Subject: Re: Request for further information AW/31/21/HH

BLOCK PLAN 1:500

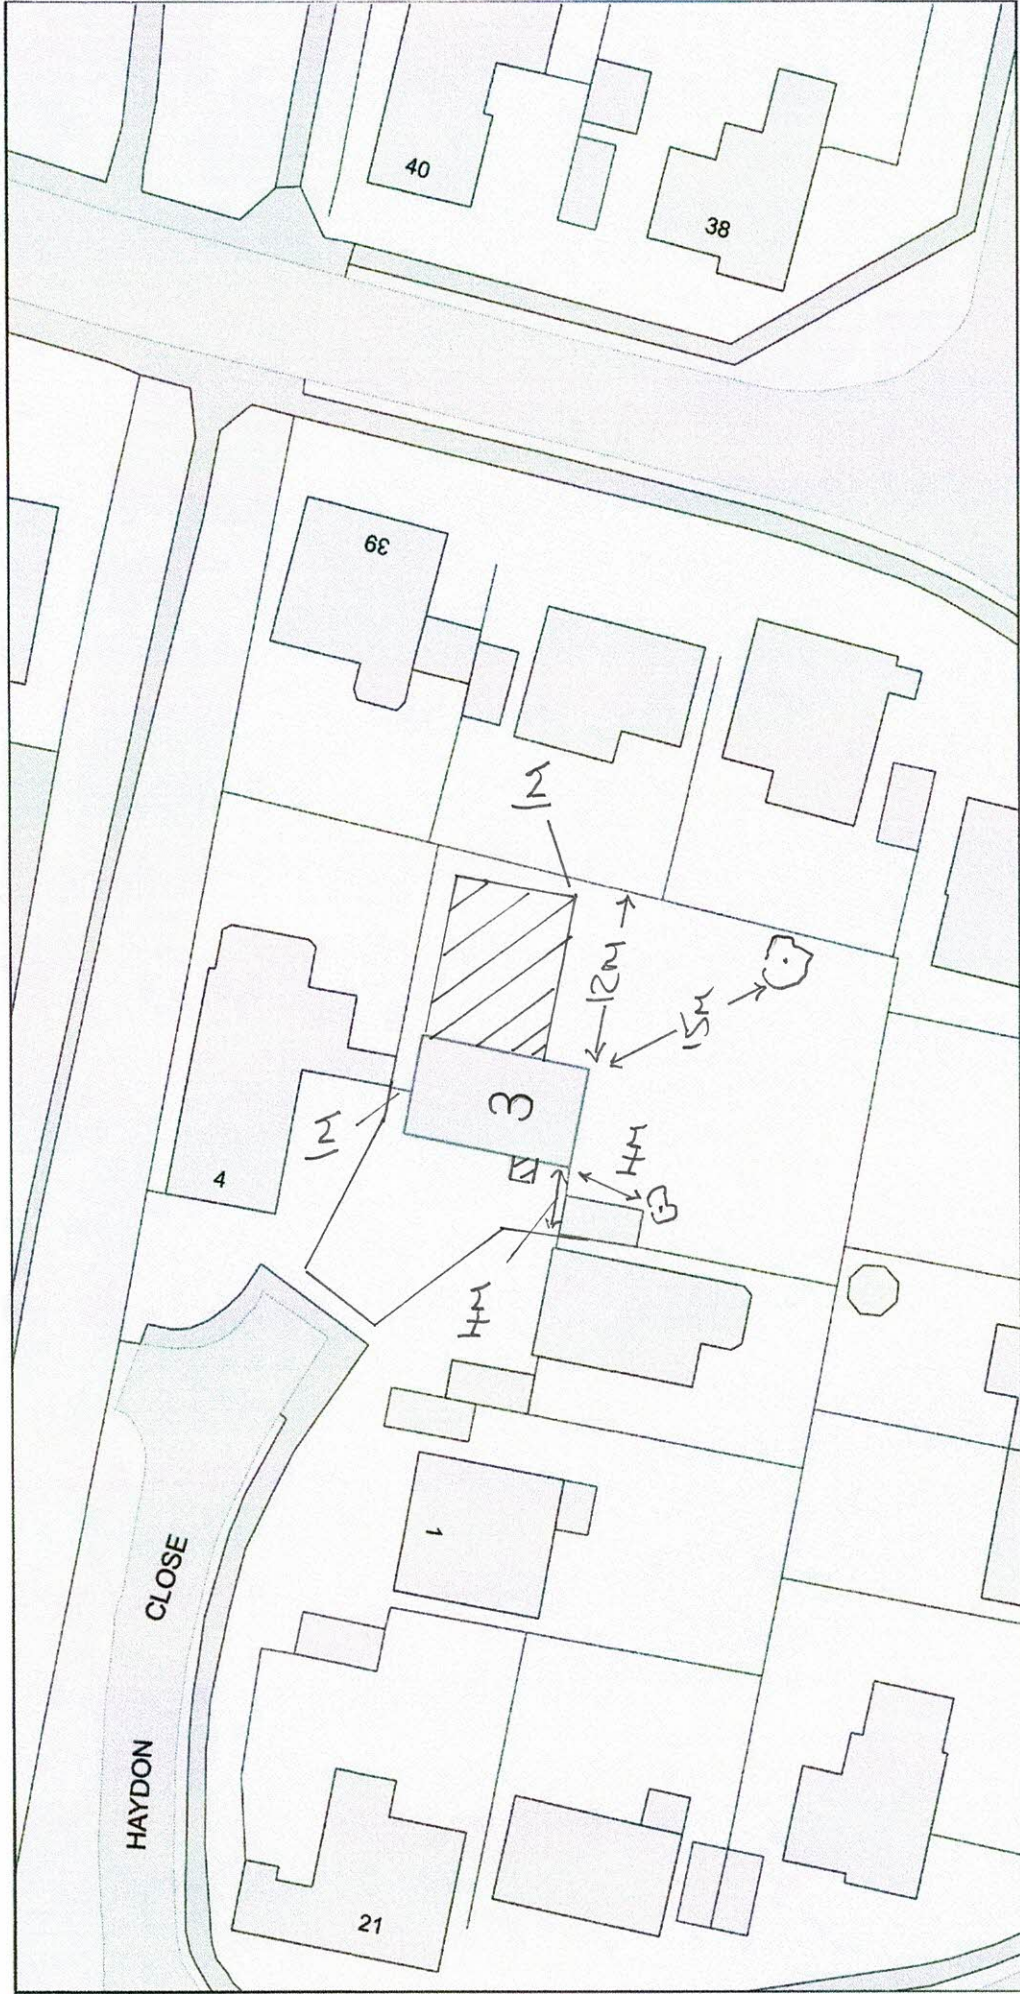
Unfortunately, this application is still invalid as the block plan requires dimensions from the proposed development to all site boundaries. Please review and amend accordingly.

The information you requested for the dimensions on the block plan were sent to you on Saturday 30th January at 15.40, however I re-attach them here for your convenience.

Further to your recent email, please see attached the ammendments requested to the Block and Location plans.
